Clonberne Wind Farm

Stage 1 Road Safety Audit

Alan Lipscombe Traffic & Transport Consultants

February 2024

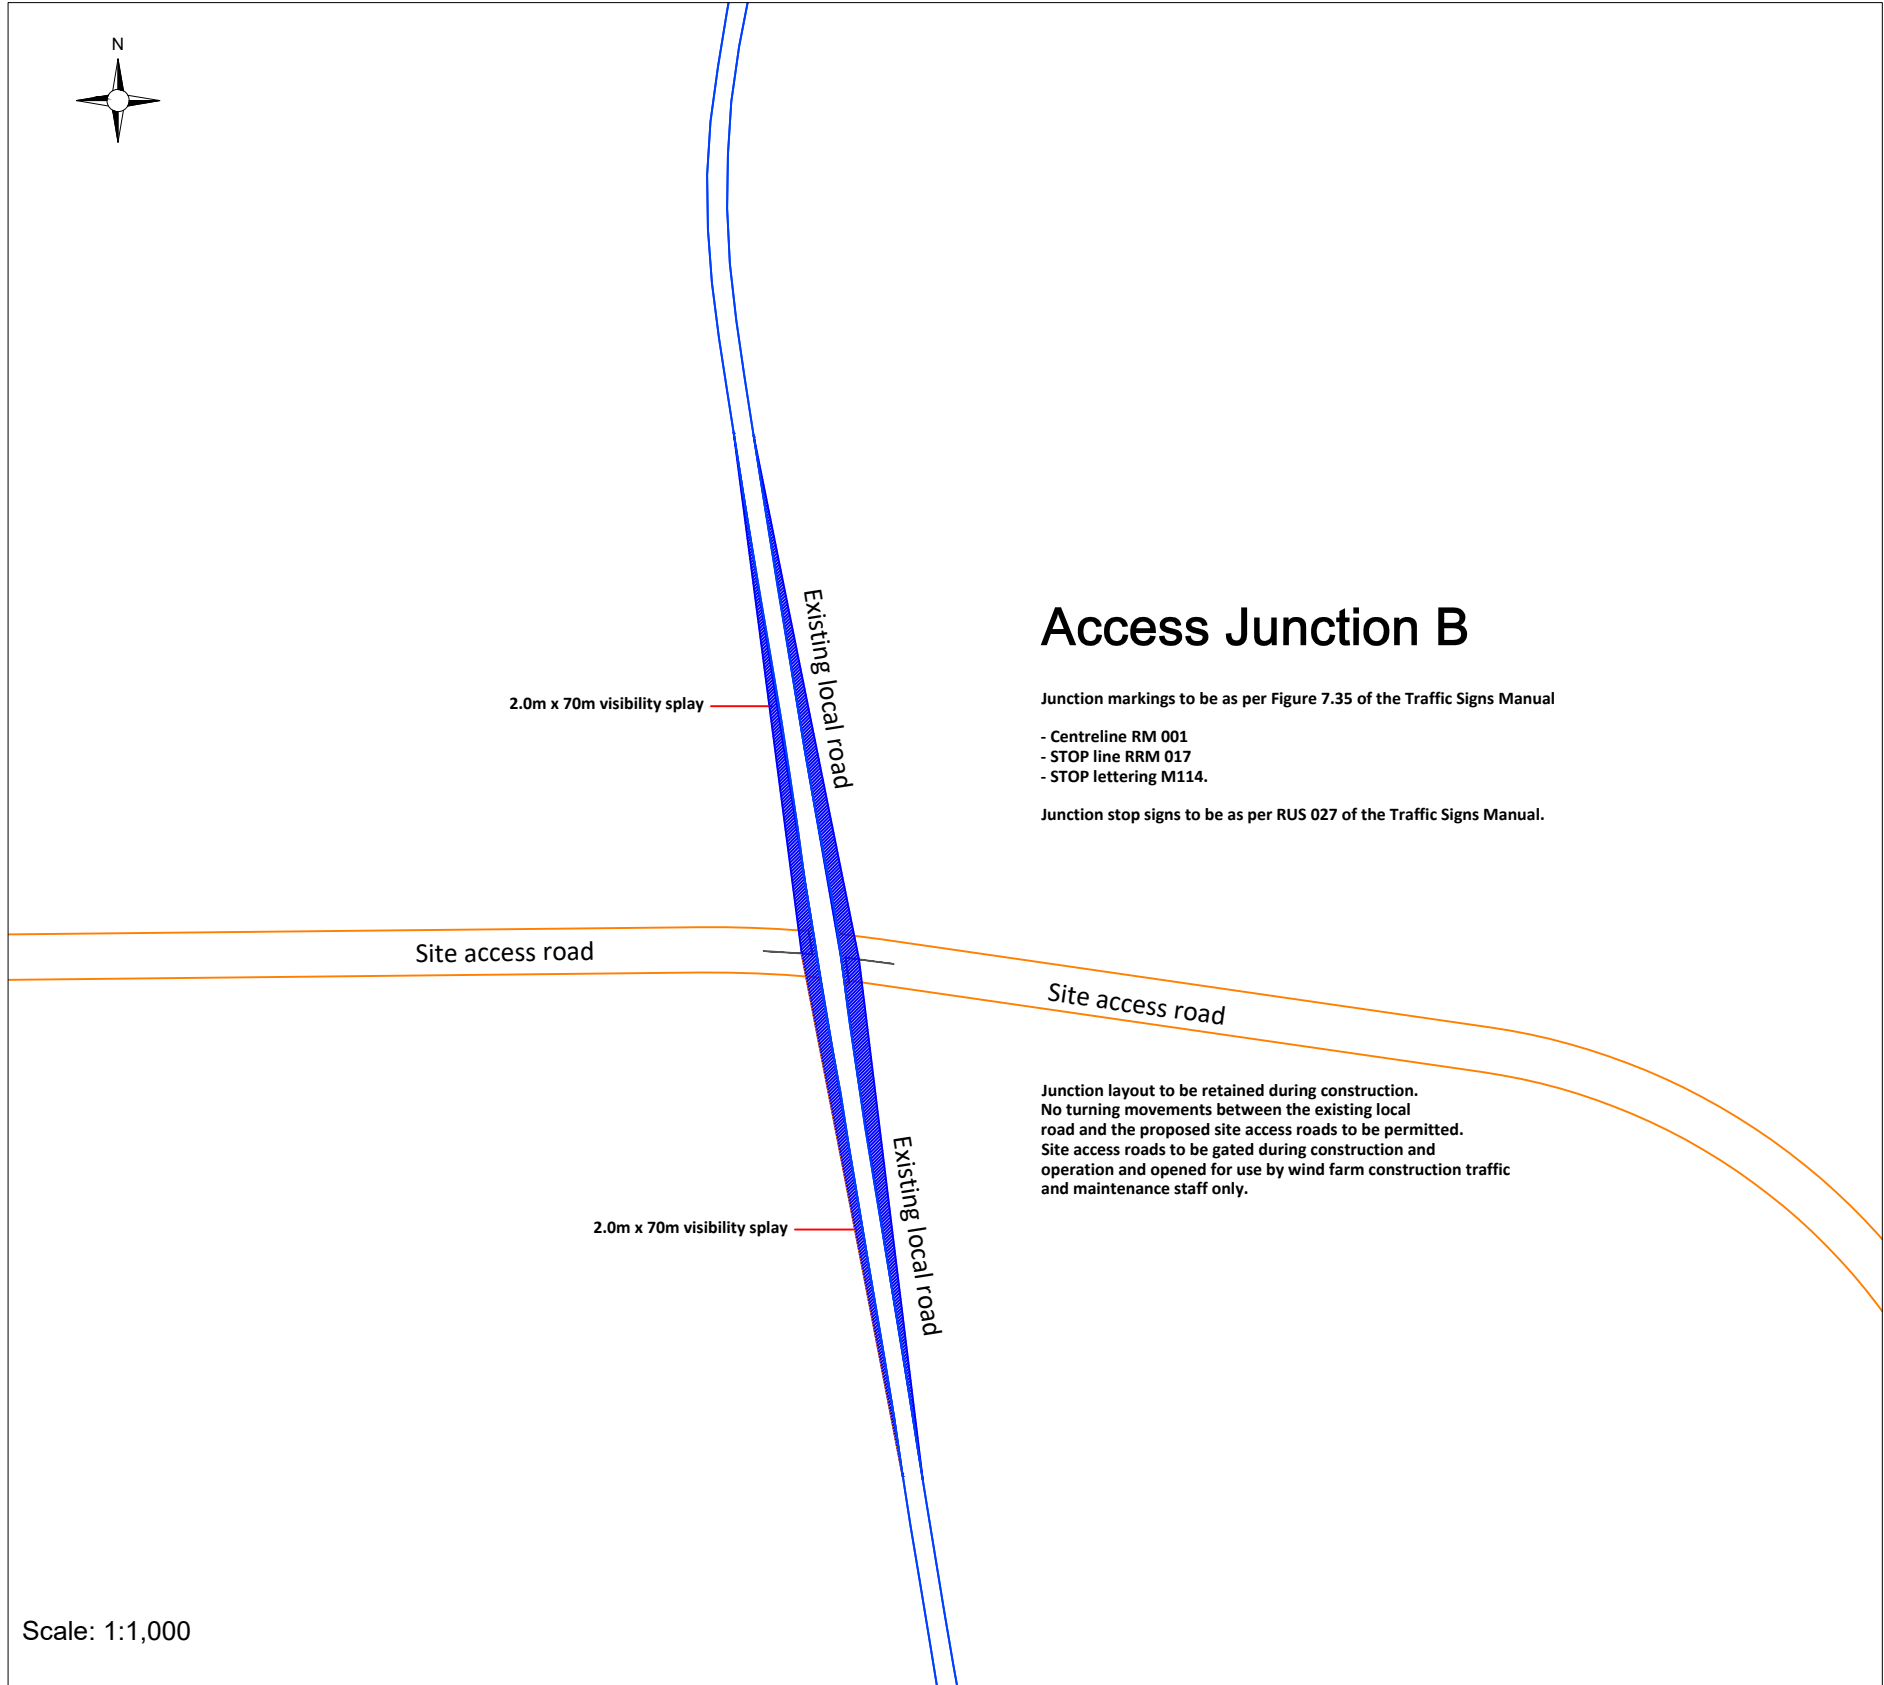
Location: Access Junction A | Emerging Driver's Line of Site Looking to Right

A driver's line of sight to approaching westbound traffic travelling on the R328 appears to be partially obscured by an existing field boundary. This is likely to increase the risk of conflict on the R328 in proximity to the temporary wind farm access during the construction period.

Appropriate sight lines should be provided at the temporary access. This should be supported with practical temporary traffic management interventions to mitigate any residual risks.

Design Team Note 1 – The available visibility splays at the main Access junction A are shown in Figure 15-29 of the EIAR. The figure shows that the area shown hatched in blue in Figure 2.1 of the RSA will be cleared as part of the proposed junction and visibility splays of 3 x 160m will be available to the west, in accordance with the 80 km/h speed limit. To the east the visibility splays are constrained to 3m x 67 metres due to site boundaries. For this reason it is proposed that this junction will be managed by means of signage and Flagmen and the introduction of a temporary reduced speed limit during the construction phase, and then permanently closed once the site Proposed Development is operational. The proposed traffic management measures are discussed in Section 15.1.10 of the EIAR.

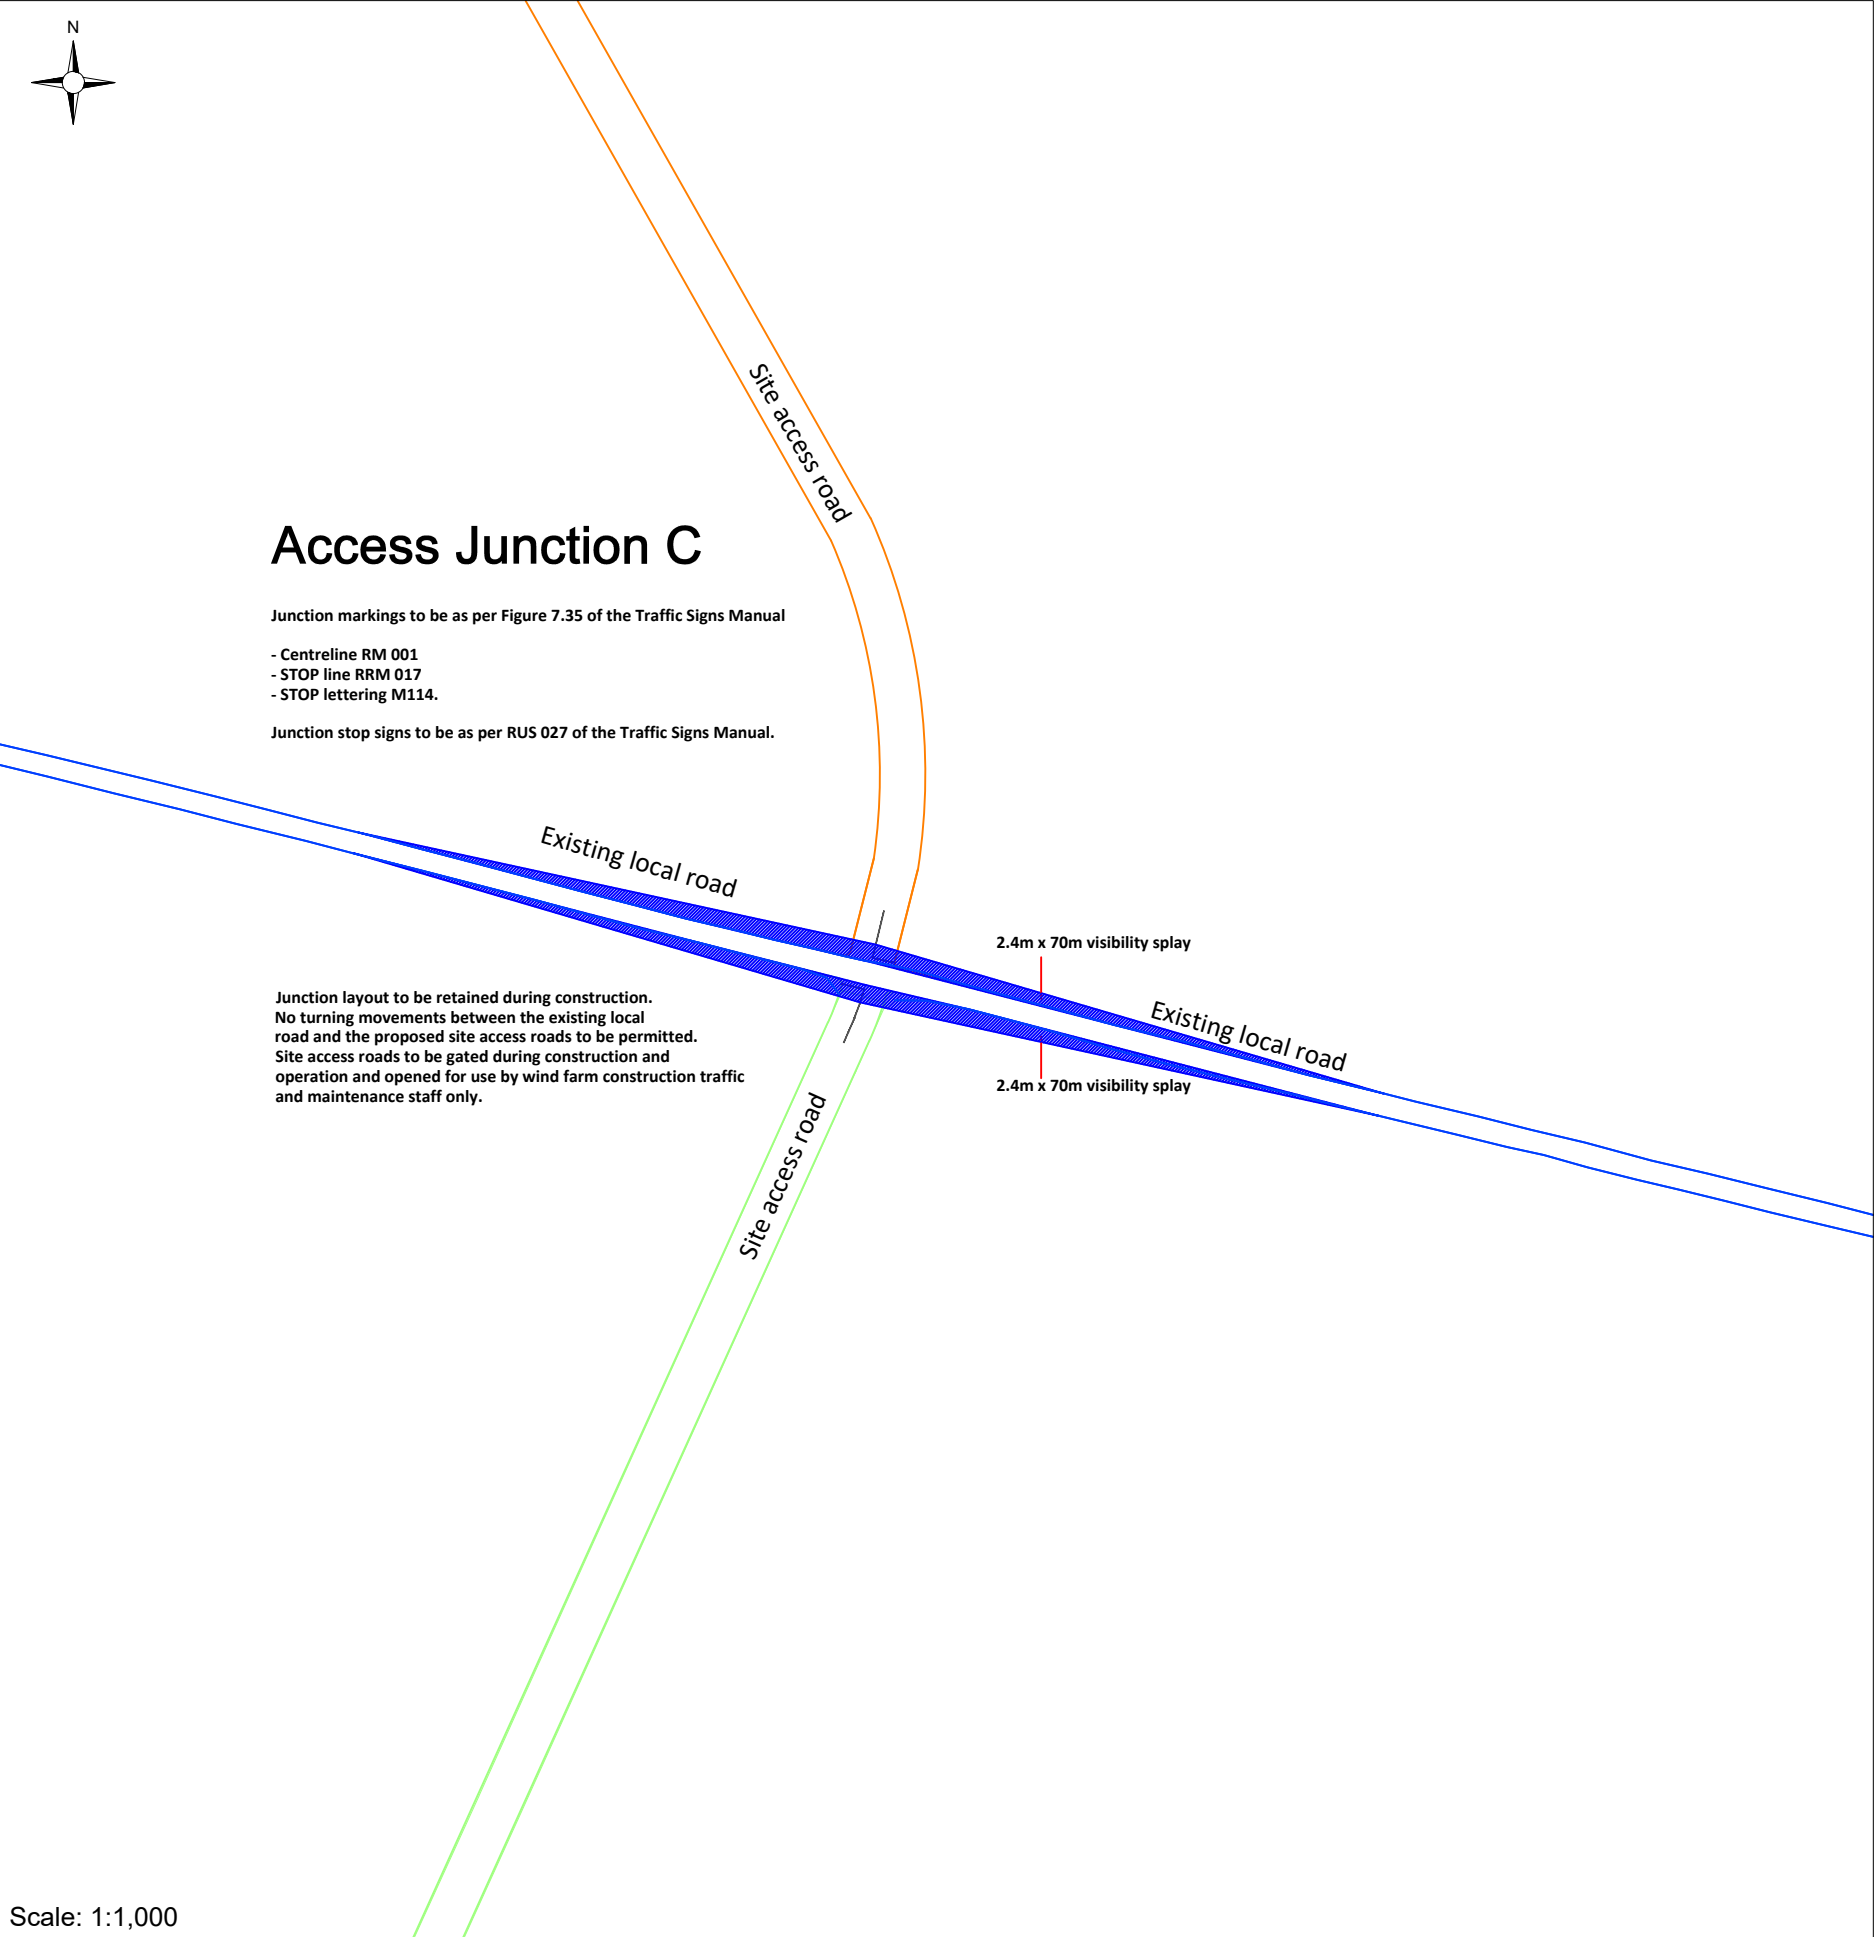
Location: Access Junctions B & C | Road Crossings

A number of the site access road approaches are long and straight. This could lead to higher approach speeds and 'failing to stop' type conflicts on the Local Roads.

Appropriate (self-regulating) temporary traffic management measures should be set in place to throttle construction traffic speed and to reduce the risk of collisions on the Local Road crossings.

Design Team Note 2 – It is proposed that signs will be put in place on the access road approaches to the local roads at Junctions B and C and that appropriate traffic management measures, including a Flagman, will be on site at all times during the construction phase. The site accesses will be closed by means of gates during all times that the accesses are not in use during construction. During the operational stage the default will be that the accesses will be closed using gates at all times and opened only during site visits made by maintenance staff. It is noted that visibility splays appropriate for the local speeds on the local road network are available at both junctions, as shown in Figures 15-33 and 15-34 of the EIAR.

DRAWING TITLE: Proposed Access Junction F	
PROJECT TITLE: Clonberne Wind Farm, Co. Galway	
DRAWING BY: Joseph O'Brien	CHECKED BY: Owen Cahill
PROJECT No.: 180740	DRAWING No.: 180740 - 43
SCALE: 1:500 @ A3	DATE: 10.06.2024

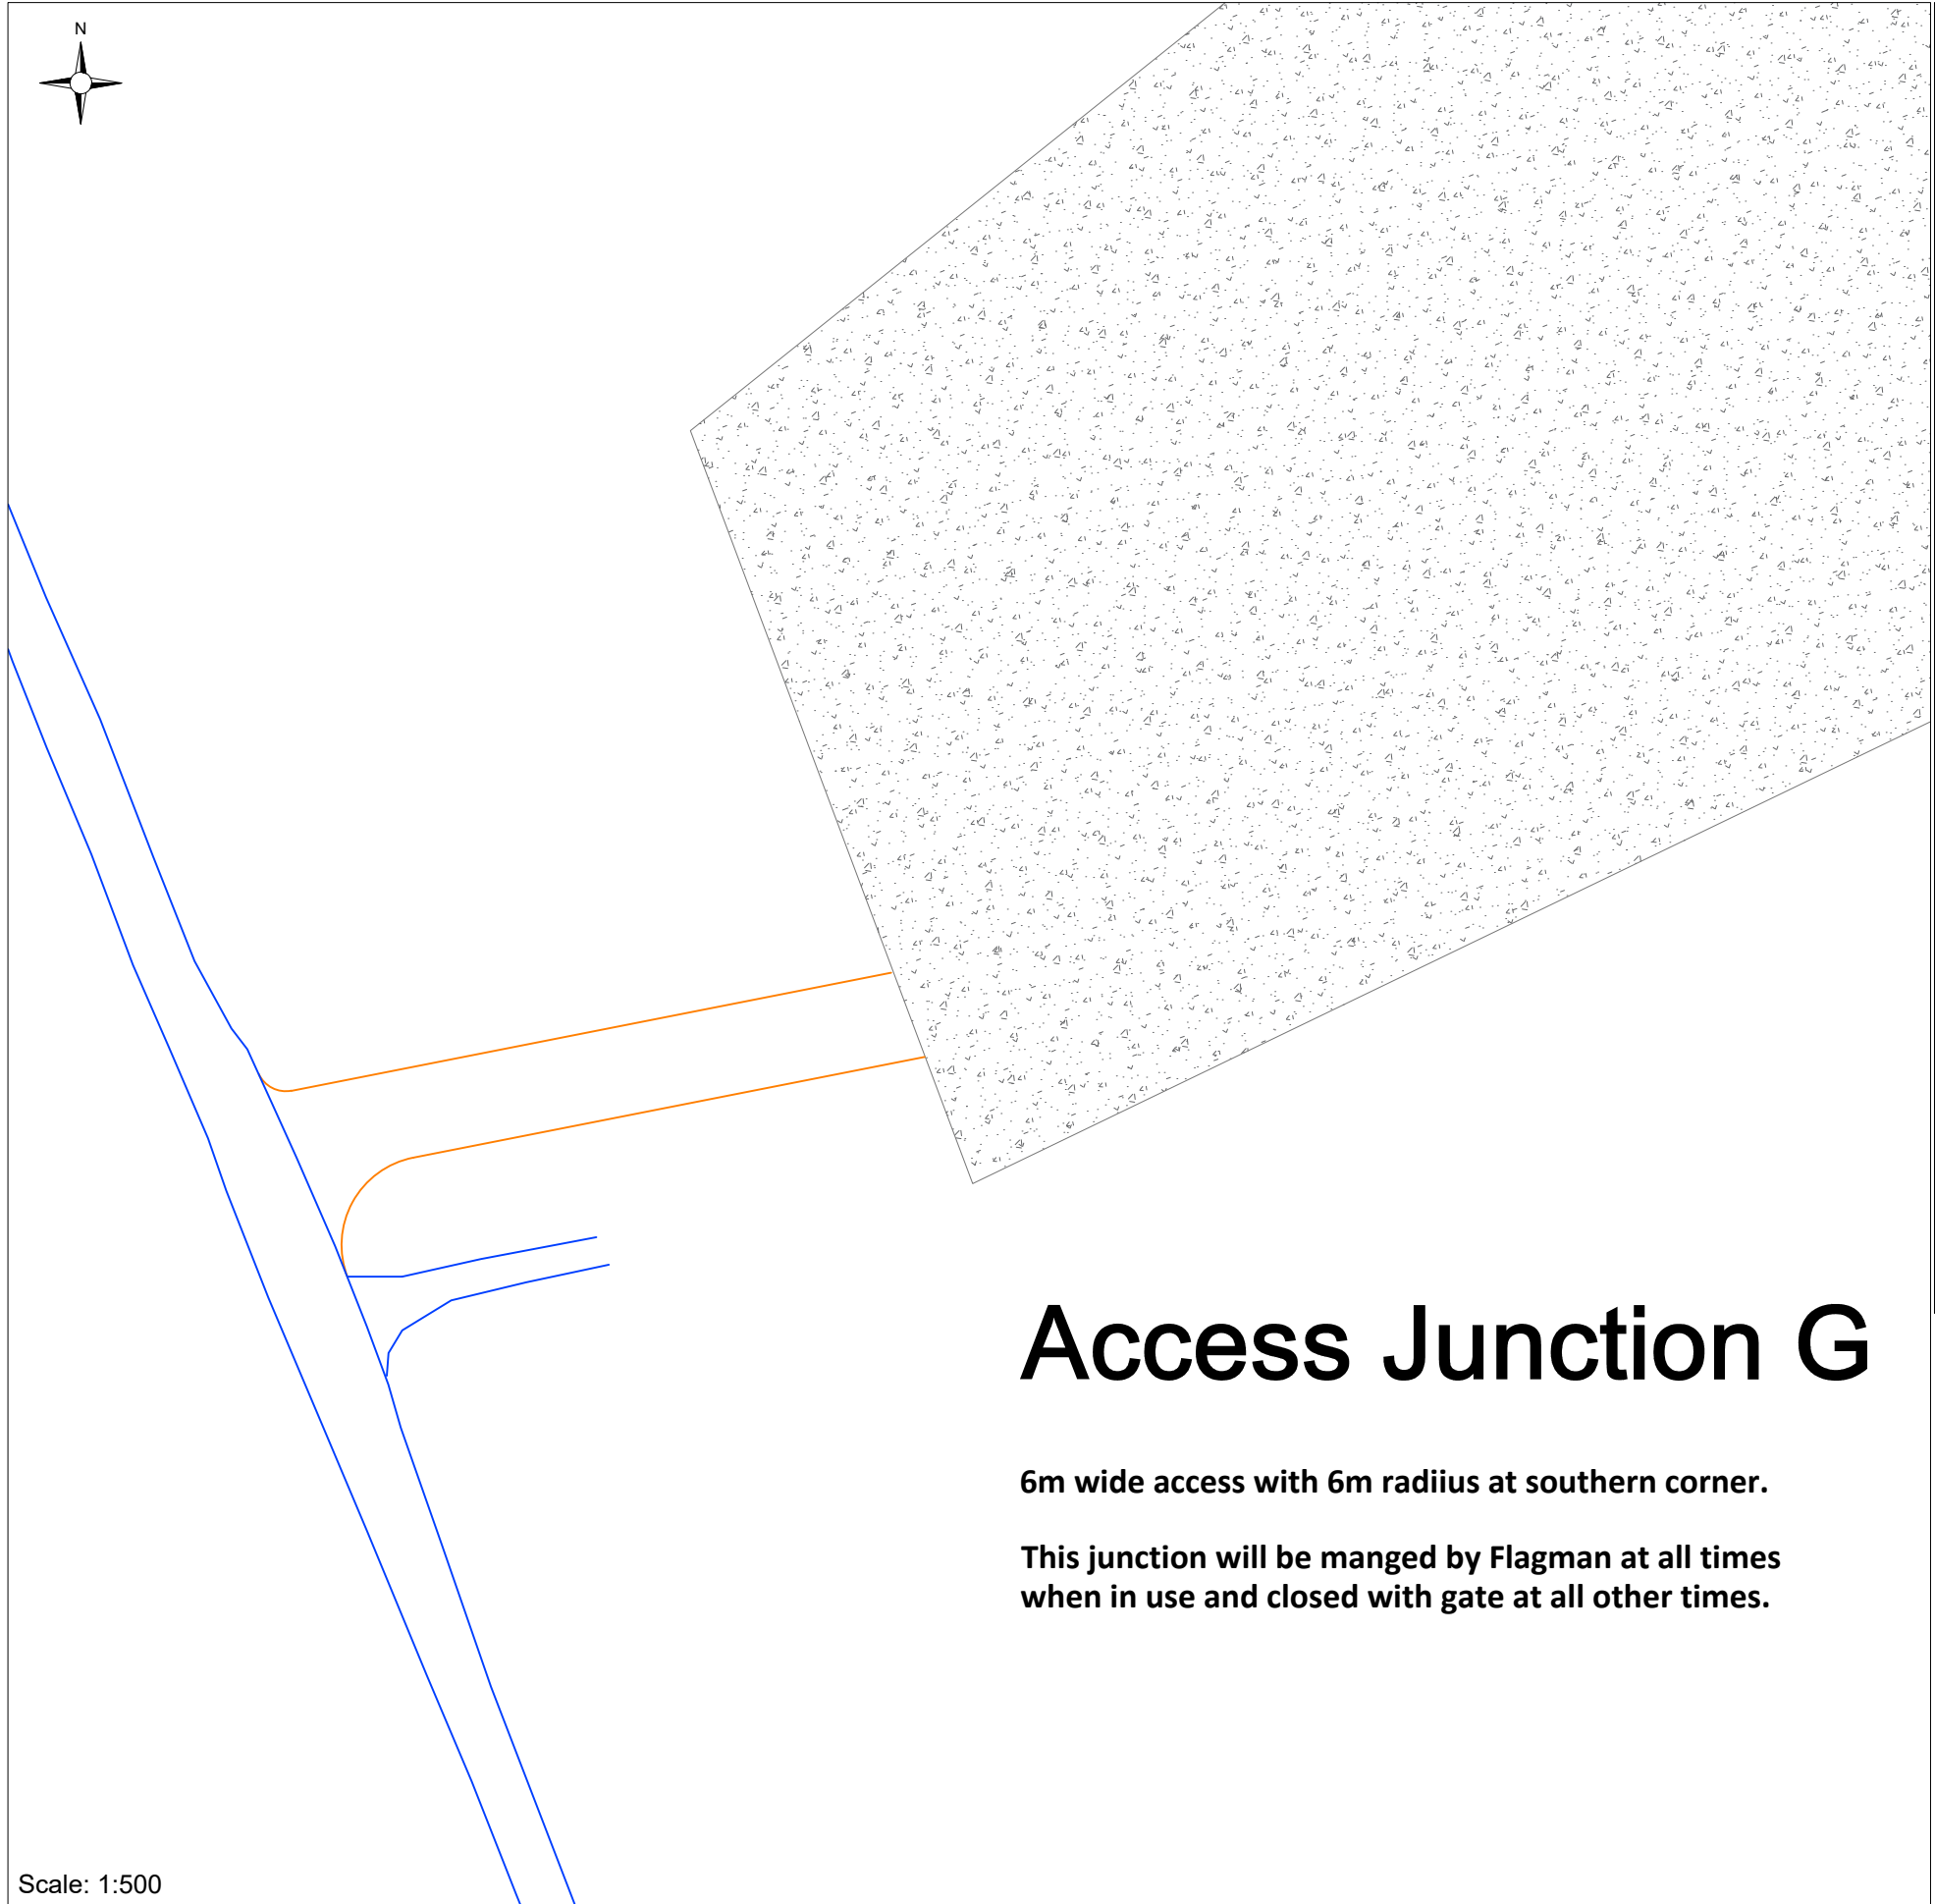
Location: Access Junction F | Southbound Approach on Local Road L-2232

The downhill approach to Access Junction F is likely to result in higher vehicle speeds. This could increase the likelihood and the severity of a collision at the junction.

Appropriate signage and road markings should be set in place to inform drivers (including drivers of construction related traffic) of the approaching junction and warn them to throttle their approach speeds.

Design Team Note 3 – It is noted that this is an existing junction and during the days that it is used to transport materials from the borrow pit to the site the junction will be controlled by traffic management measures, including temporary signing and a Flagman, which will calm local traffic speeds. Once the construction phase is complete there will be no development generated traffic passing through this junction.
